## NSW RURAL FIRE SERVICE

Your Ref: SSD 9575 MOD2  
Our Ref: D18/7053

**Agency Comment - Proposed New Tweed Valley Hospital Stage 1 Concept approval and Early Works (SSD 9575 MOD2); 771 Cudgen Road, Cudgen**

DRAWING No AR-SKE-10-110

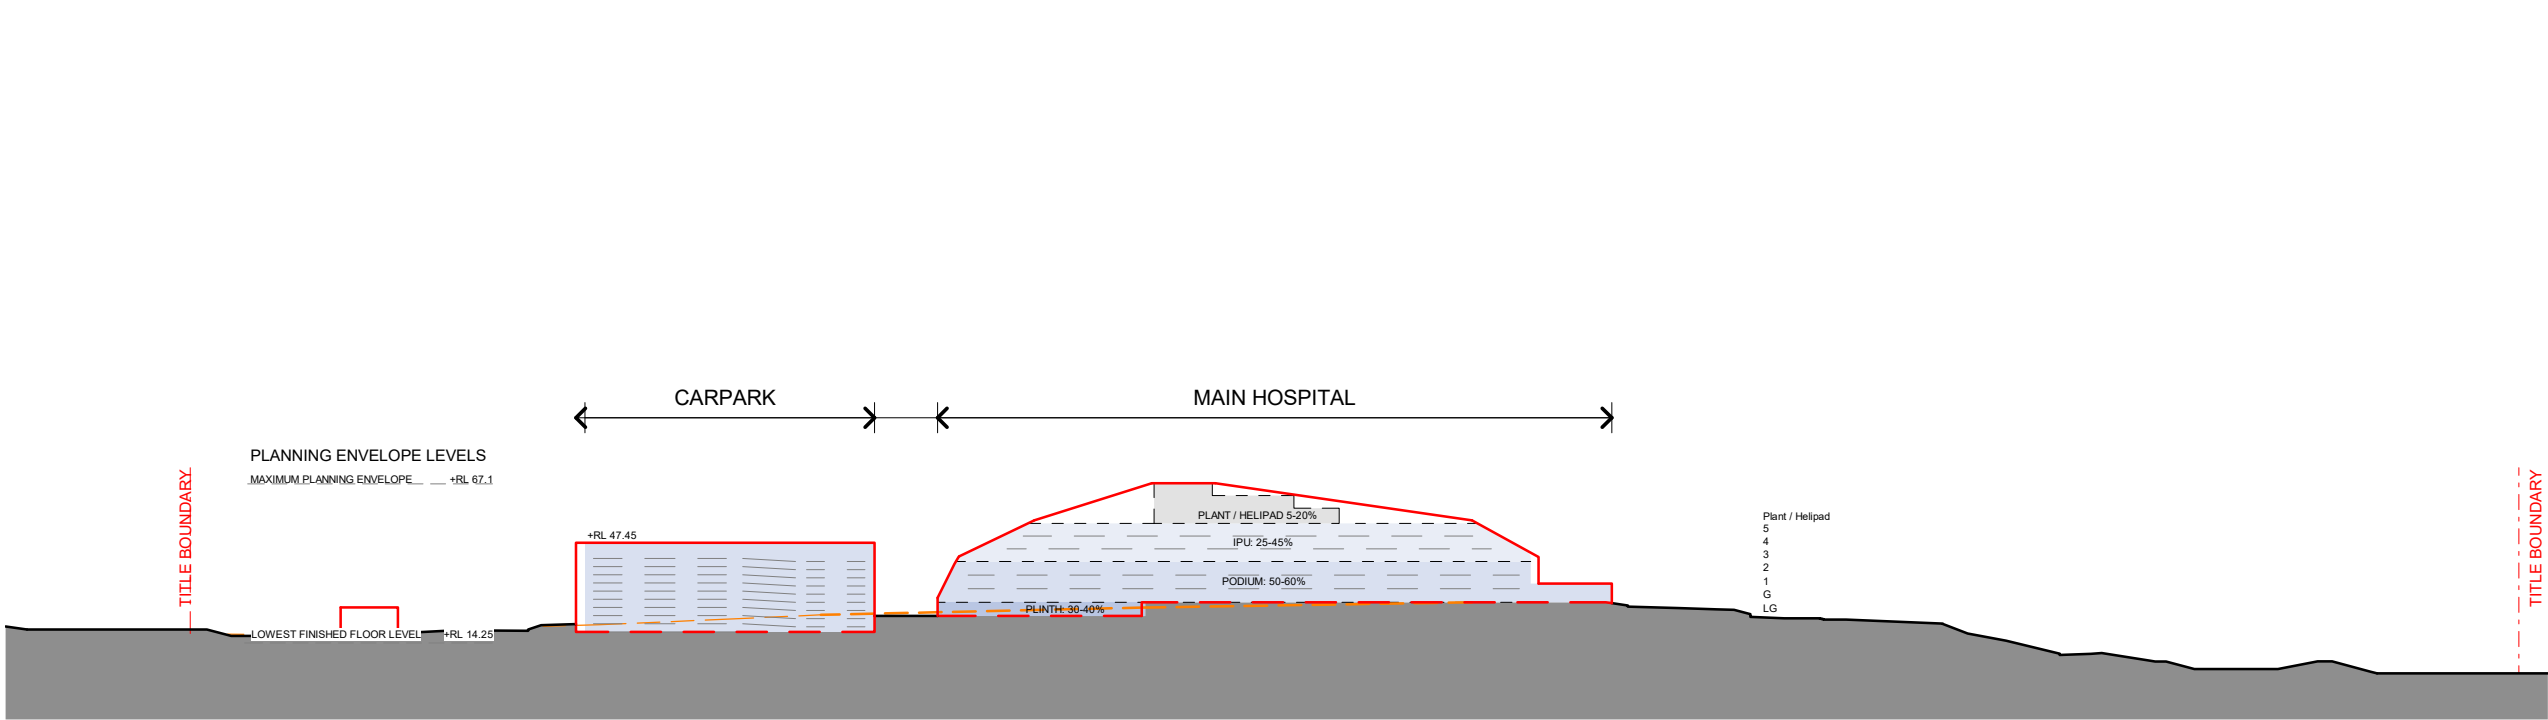
1. The development proposal is to comply with the Masterplan Plan-Concept Plan, prepared by STH Bates Smart for TSA Management numbered AR-SKE-10-006 revision 8 dated 11 September 2019.
2. At commencement of physical site works associated with stage 1 Early/Enabling Works, the tree line as identified in the Masterplan-Concept plan shall be surveyed and physically delineated using Mesh Banner fencing or similar.
3. At commencement of physical site works associated with stage 1 Early/Enabling Works, the proposed APZ and construction area as identified in the Masterplan-Concept plan shall be managed as an inner protection area (IPA) as outlined within section 4.1.3 and Appendix 5 of 'Planning for Bush Fire Protection 2006' and the NSW Rural Fire Service's document 'Standards for asset protection zones'.
